Rezoning Transportation Analysis

Petition Number: 2020-039

General Location Identifier: Tax ID 12709221

**SKETCH PLAN**

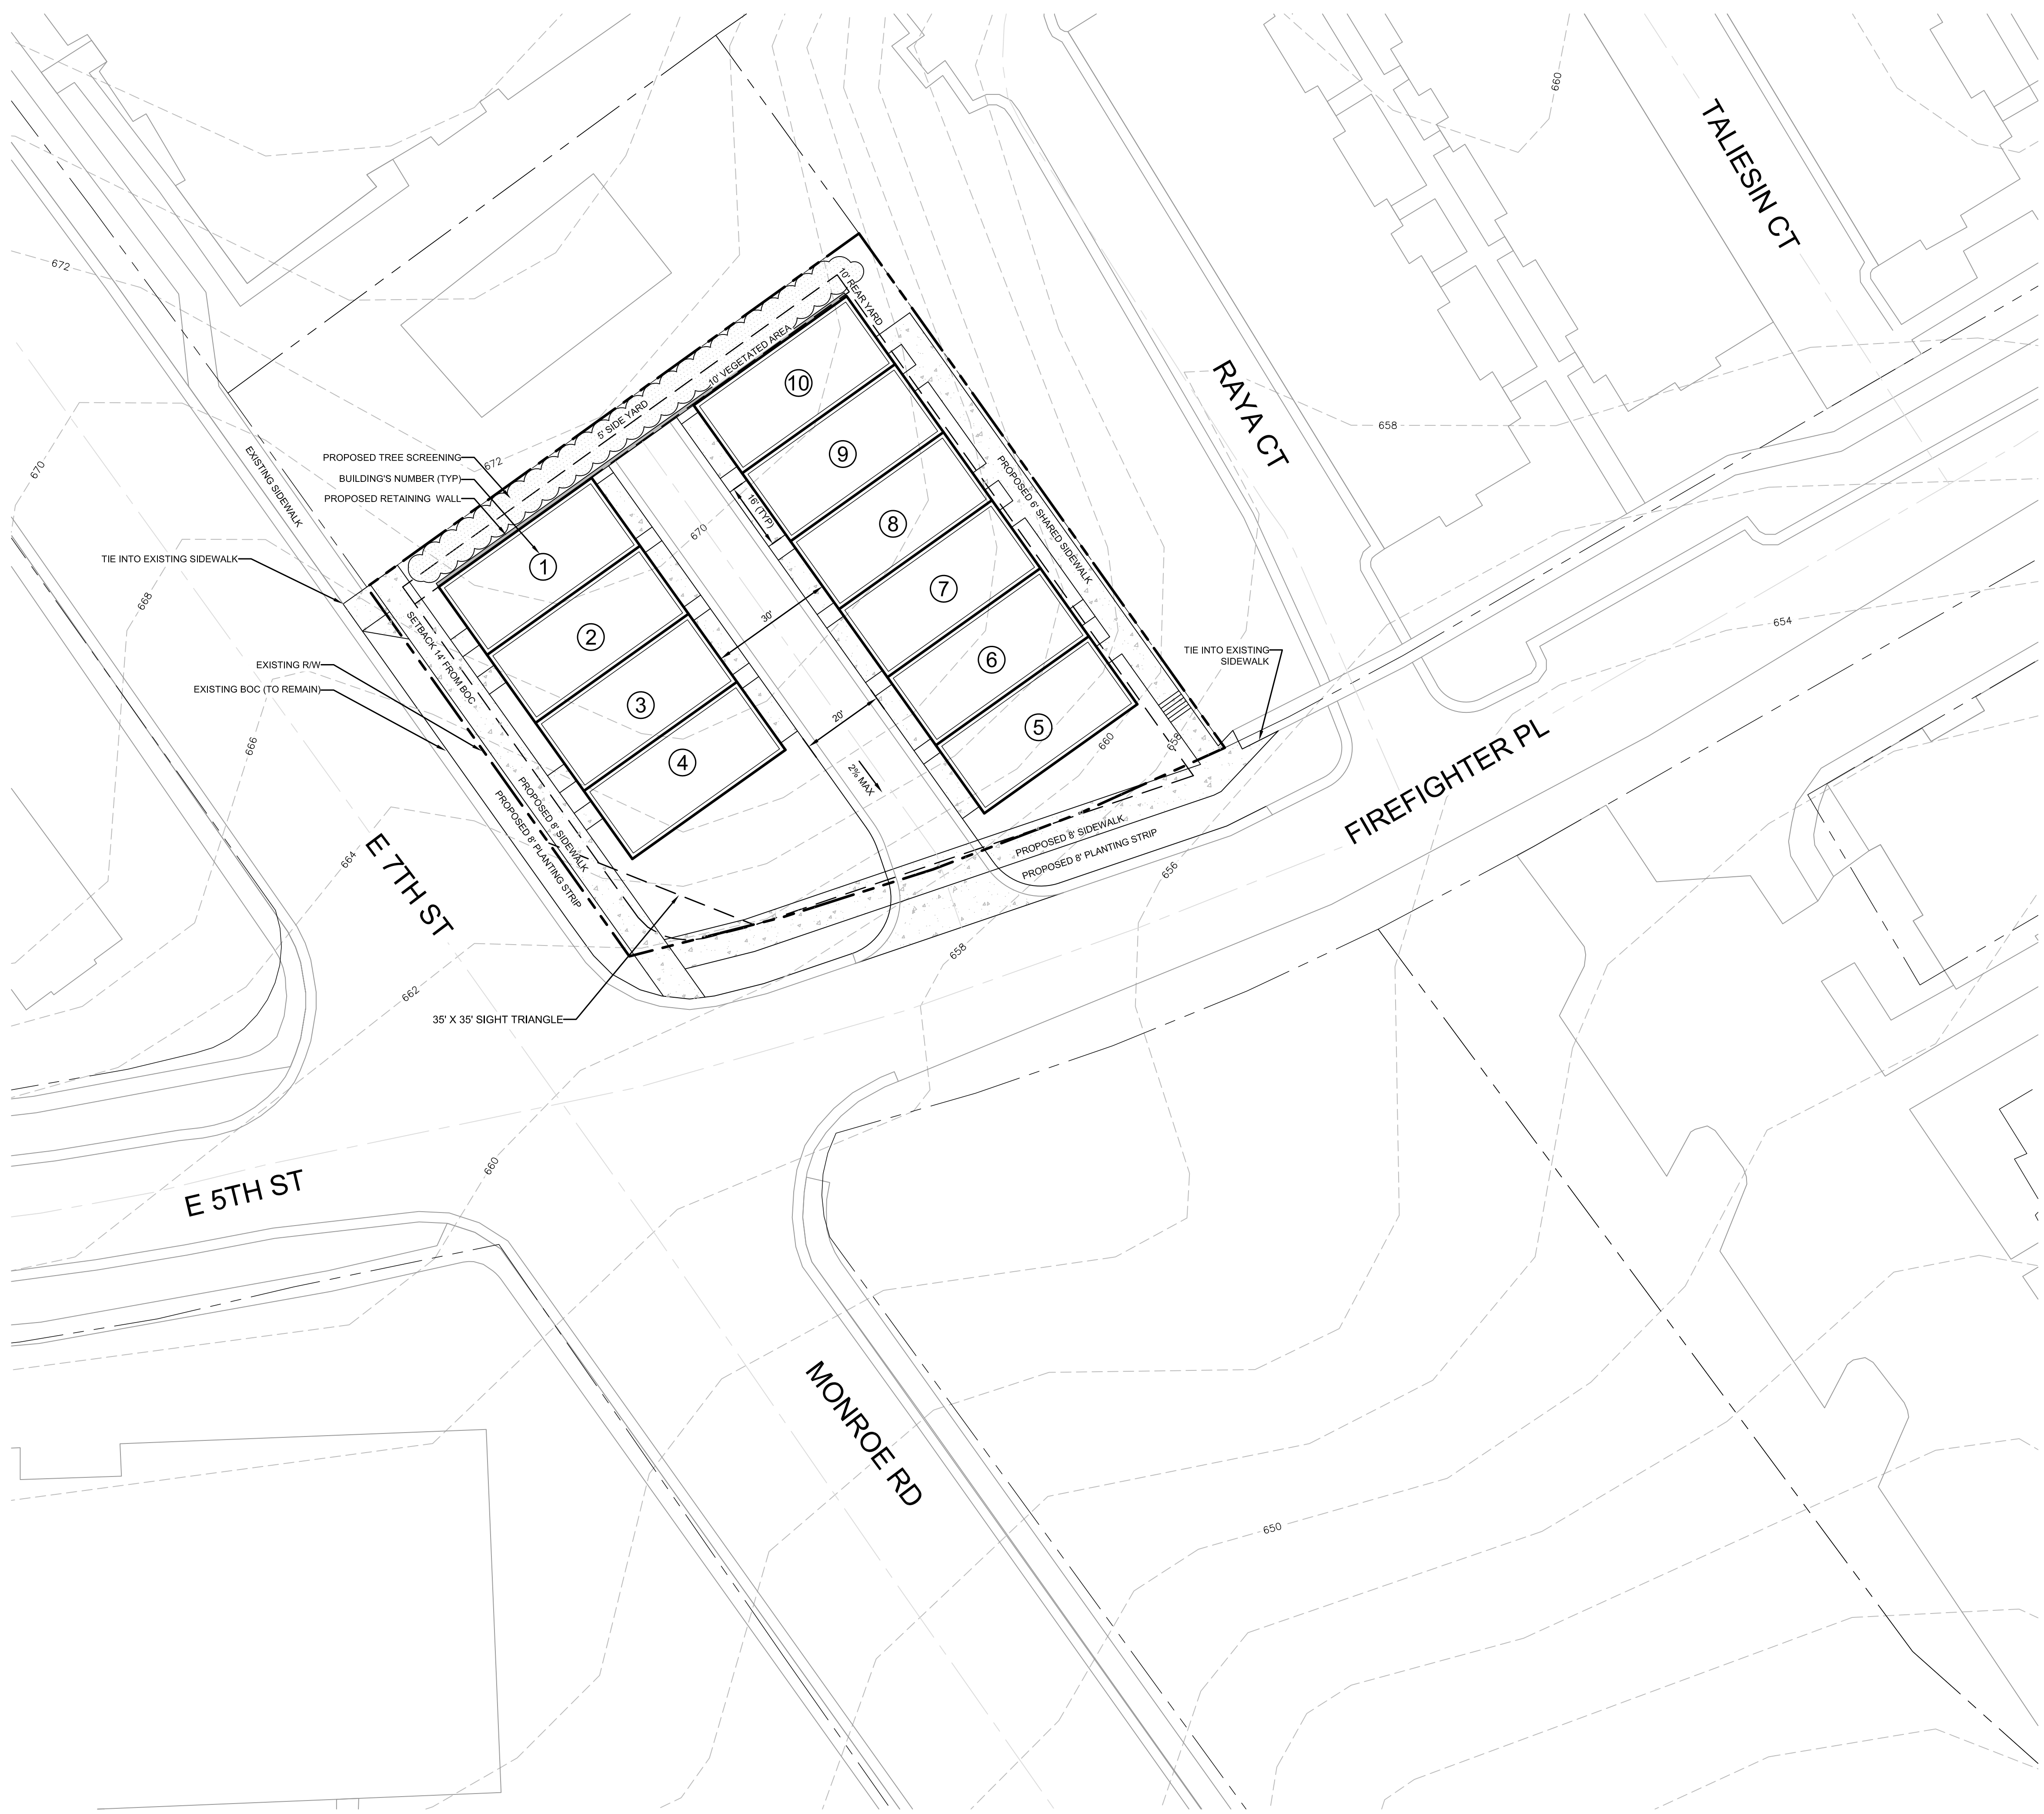
1. **Curbline** The proposed zoning district has a setback measured from back of the existing or proposed future curbline.
 - a. **Monroe Road:** The future location of curb and gutter is in its existing location.
 - b. **Firefighter Place:** The future location of curb and gutter is in its existing location.

The site plan should show the curb and gutter labeled and dimensioned from the centerline for each road.

3. The petitioner should revise the site plan and conditional note(s) to commit to dedicate 40' of right-of-way from the road centerline, as it is a major thoroughfare and within Route 4. The site plan should label and dimension the right-of-way from the road centerline.

4. The petitioner should revise the site plan and conditional note(s) to commit to construct dual ramps at the corner of E 7th Street and E. 5th Street to meet the City's Charlotte WAKS Policy and PROWAG. In addition, the developer should commit to provide accessible push buttons for its corner. The site plan should label and dimension both items from the back of curb and gutter and road centerline.

5. We request for the petitioner should revise the site plan and conditional note(s) to commit to construct dual ramps at the corner of Monroe Road and E. 5th Street to meet City's Charlotte WAKS Policy and PROWAG. The site plan should label and dimension both items from the back of curb and gutter and road centerline.

6. The petitioner should revise the site plan to add a note specifying dedication and fee simple conveyance of all rights of way to the City before the site's first building certificate of occupancy is issued. CDOT requests right of way set at 2' behind back of sidewalk where feasible.
7. The petitioner should revise the site plan to add a note specifying all transportation improvements will be approved and constructed before the site's first building certificate of occupancy is issued. The petitioner may phase transportation improvements if said improvements and phasing are explicitly described in site plan notes.
8. **Resolved** Sample format for comment that is resolved
